Application No: EP/93/20/HH
Site Address: 7 North Lane East Preston BN16 1BN
Description of works: Erection of a outbuilding for use as a garden store.

Thank you for your internet representation made on 8th October 2020 which has been recorded as an objection with the comments as follows:

Drawing Title:
Site Plan

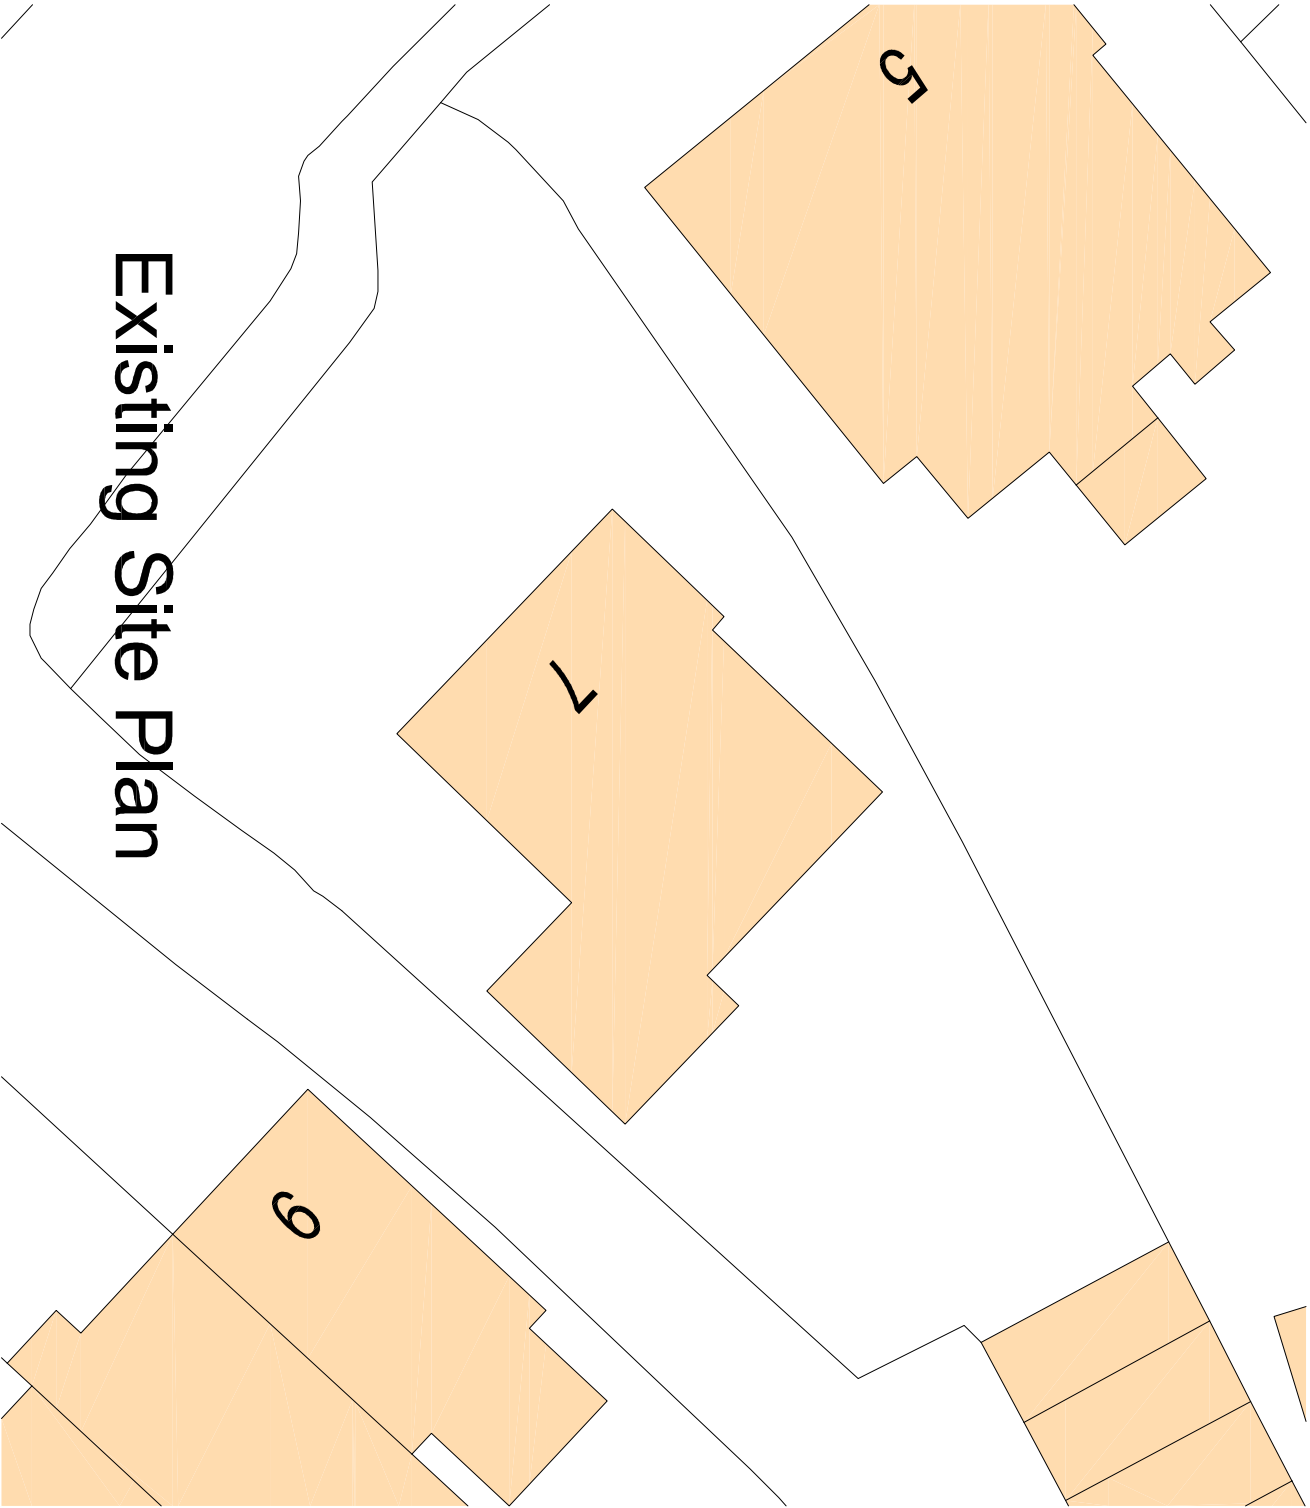
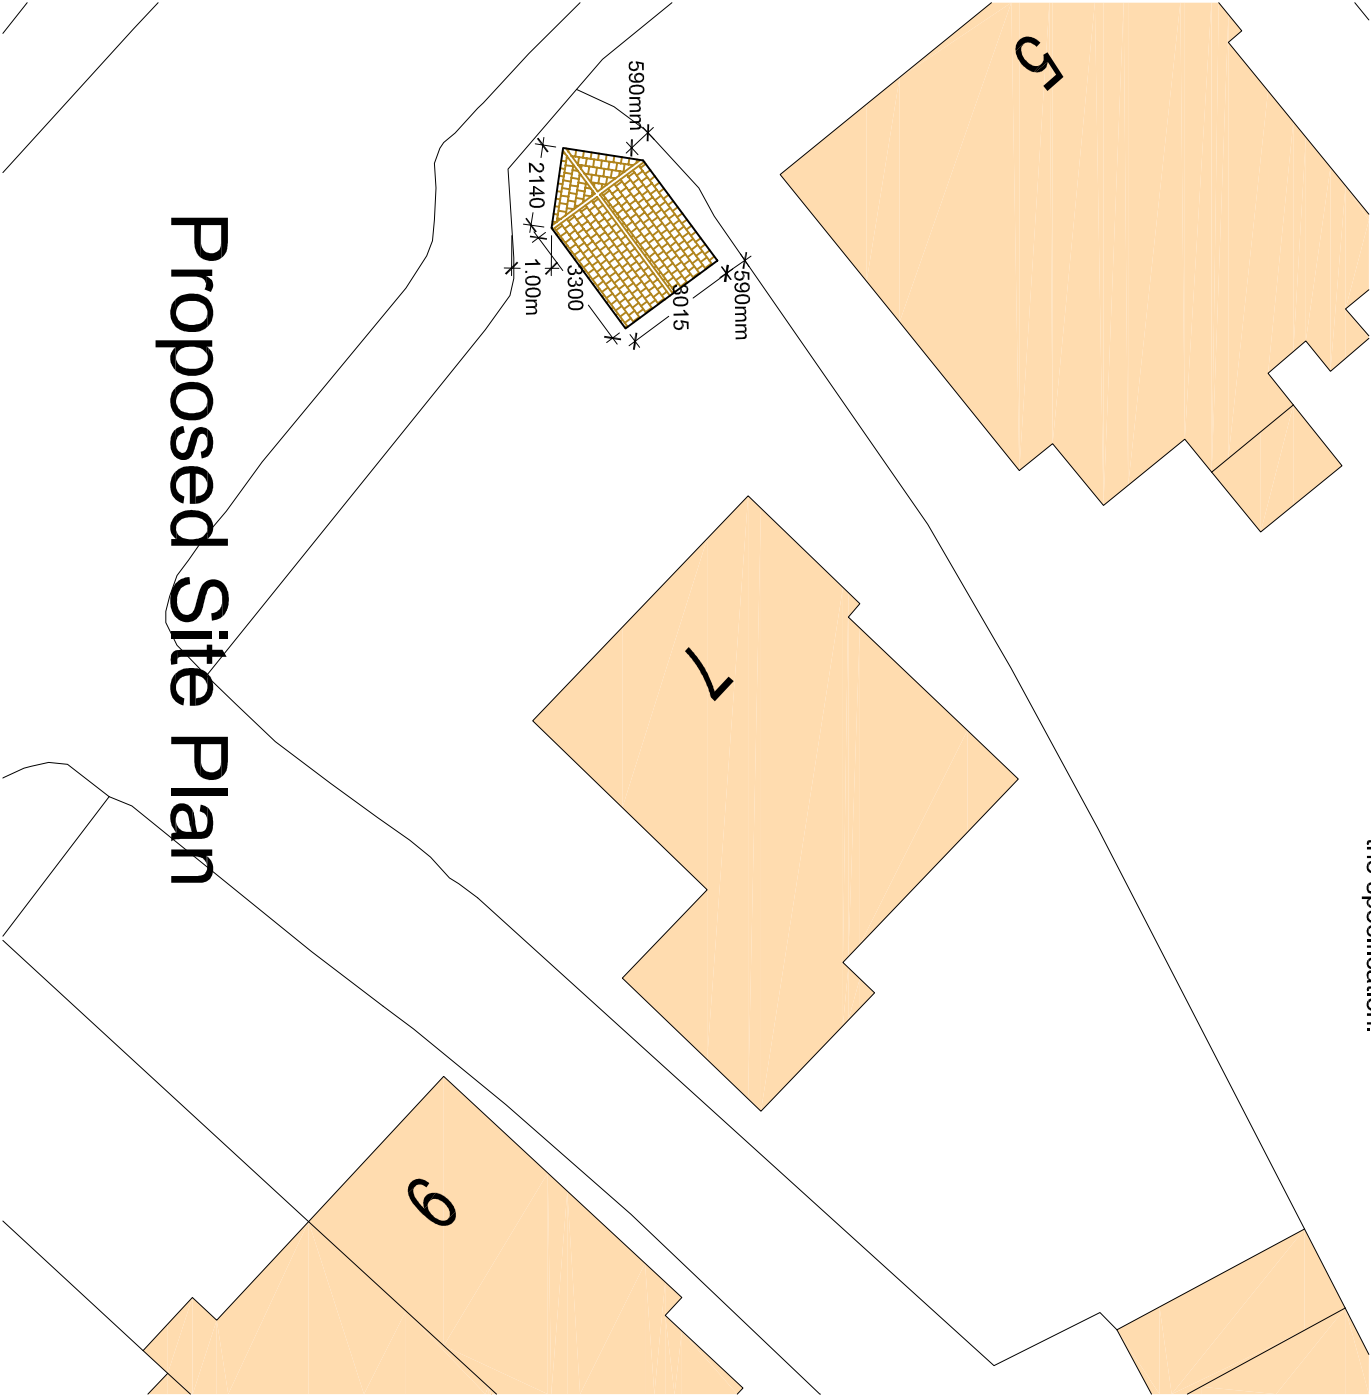
The proposal to place a large wooden shed in front of a house and on the edge of the road contravenes the most elementary rules of good planning. It is also contrary to Policy D DM1 of the Arun Local Plan because it does not reflect the character of the area; Policy 1 of the East Preston Neighbourhood Plan, because it does not preserve the street scene; and Policy 5 of the Neighbourhood Plan, which requires that high front garden walls or fences are avoided. The shed would, like a high fence, break the open character of the road that is created by low garden walls.
